CITY OF PORTLAND BUILDING PERMIT

222 RIVERSIDE ST

PERMIT ID: 2013-00396 ISSUE DATE: 05/01/2013 CBL: 316 B004001

has permission to **Change of use from landscaping business to retail & wholesale of commercial fishing equipment & manufacturing of wire lobster traps - no construction** provided that the person or persons, firm or corporation accepting this permit shall comply with all of the provisions of the Statues of Maine and of the Ordinances of the City of Portland regulating the construction, maintenance and use of the buildings and structures, and of the application on file in the department.

add dimensions
MAIN BUILDING
CROSS SECTION

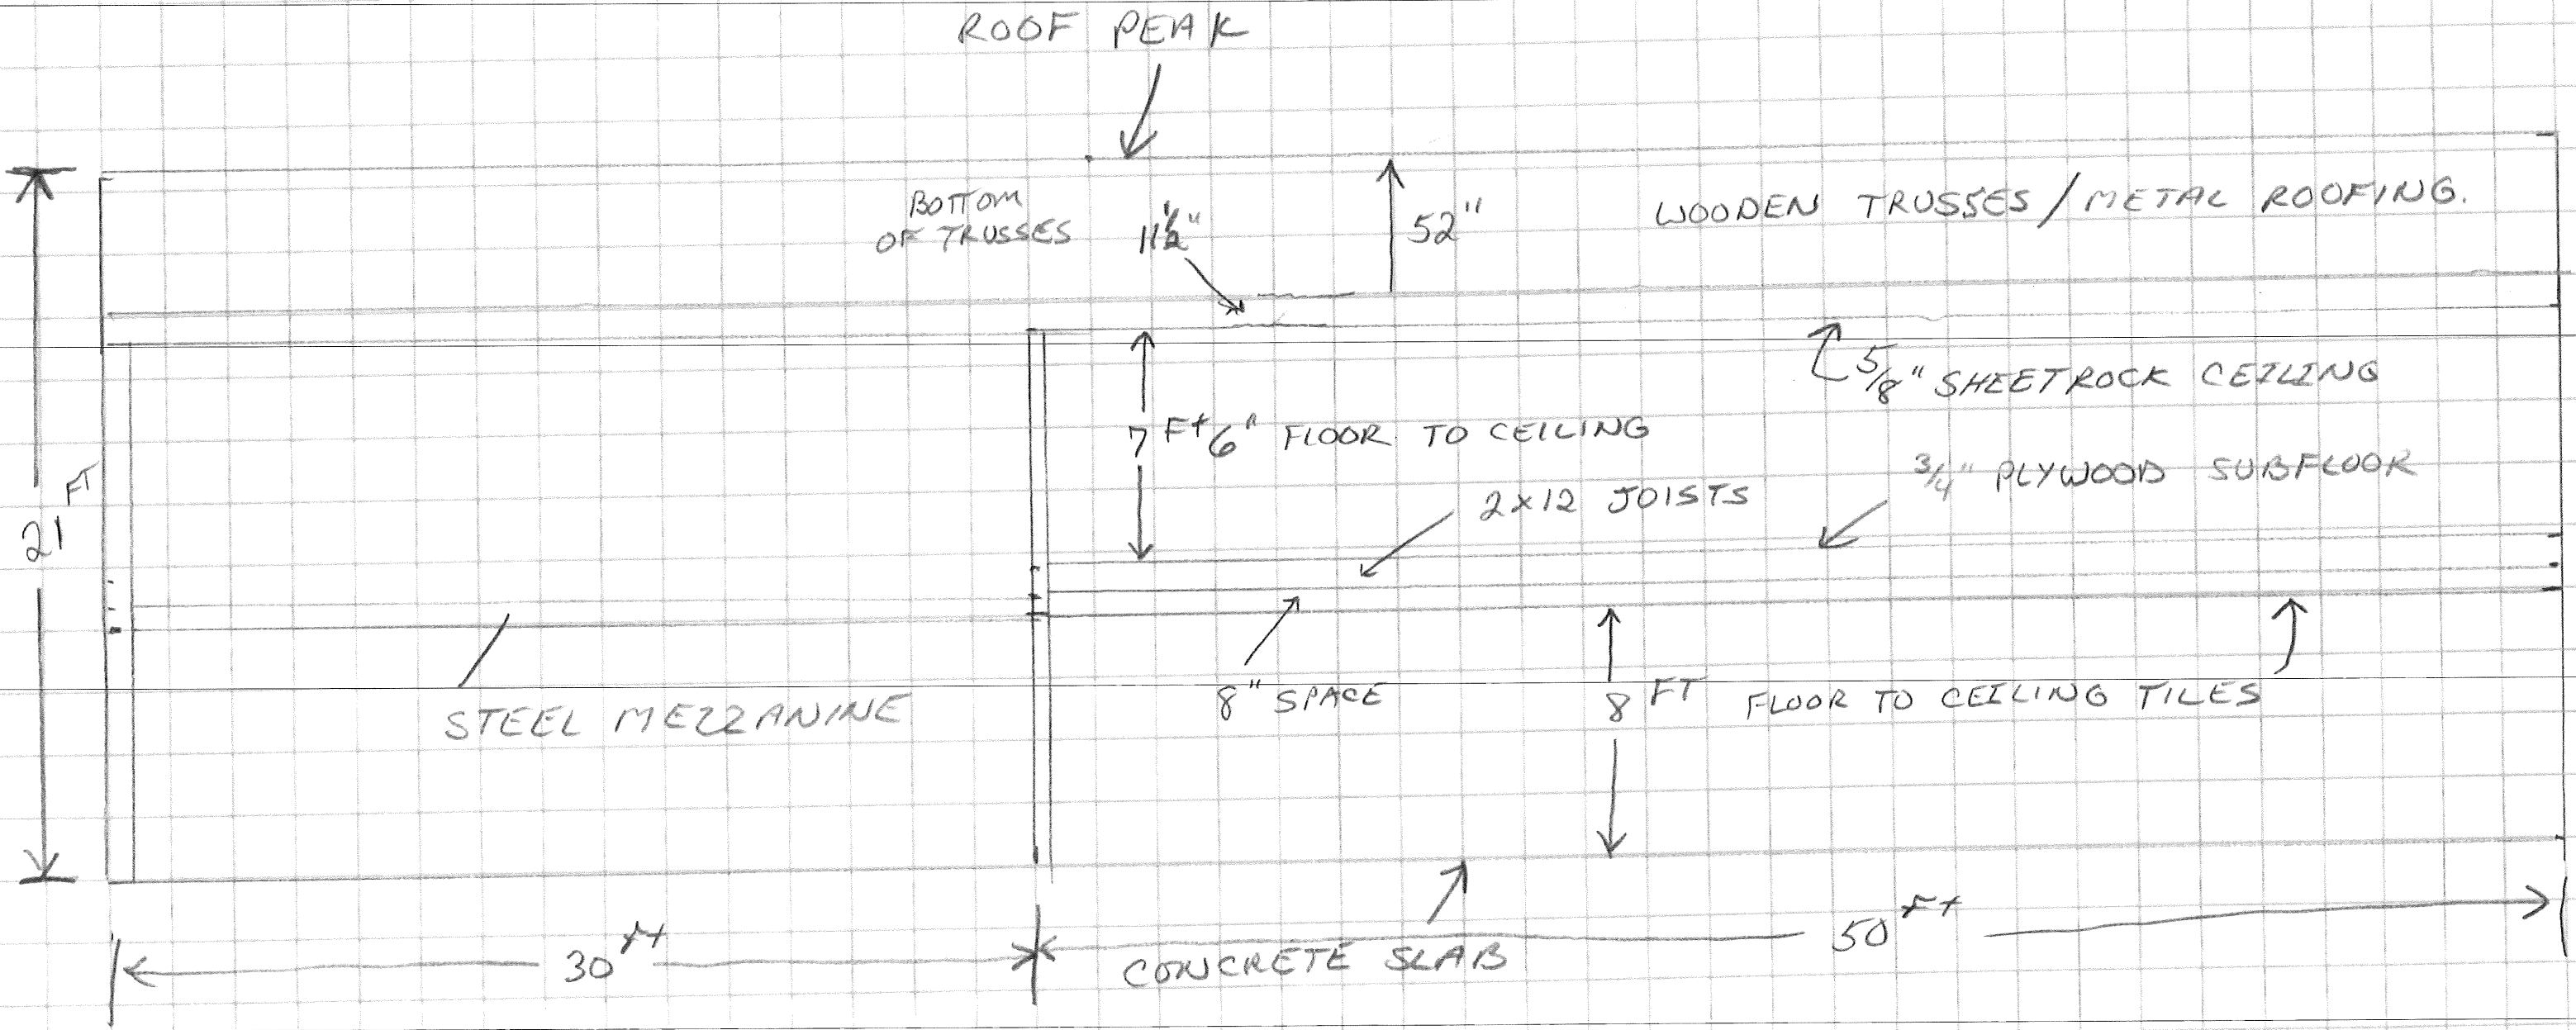
If the building is a M Retail or Wholesale Stores & F-2 Metal Products (Fabricating and Assembly) Table 508.4 requires a 1 hour separation of occupancies for sprinkled buildings or 2 hours for non sprinkled.

Are these uses separated from the first floor to the second floor offices and storage?

Is there a mezzanine or is it a full second floor?

Mark please submit new drawing, cross-section and floor plans indicating the information identified on the attached document.
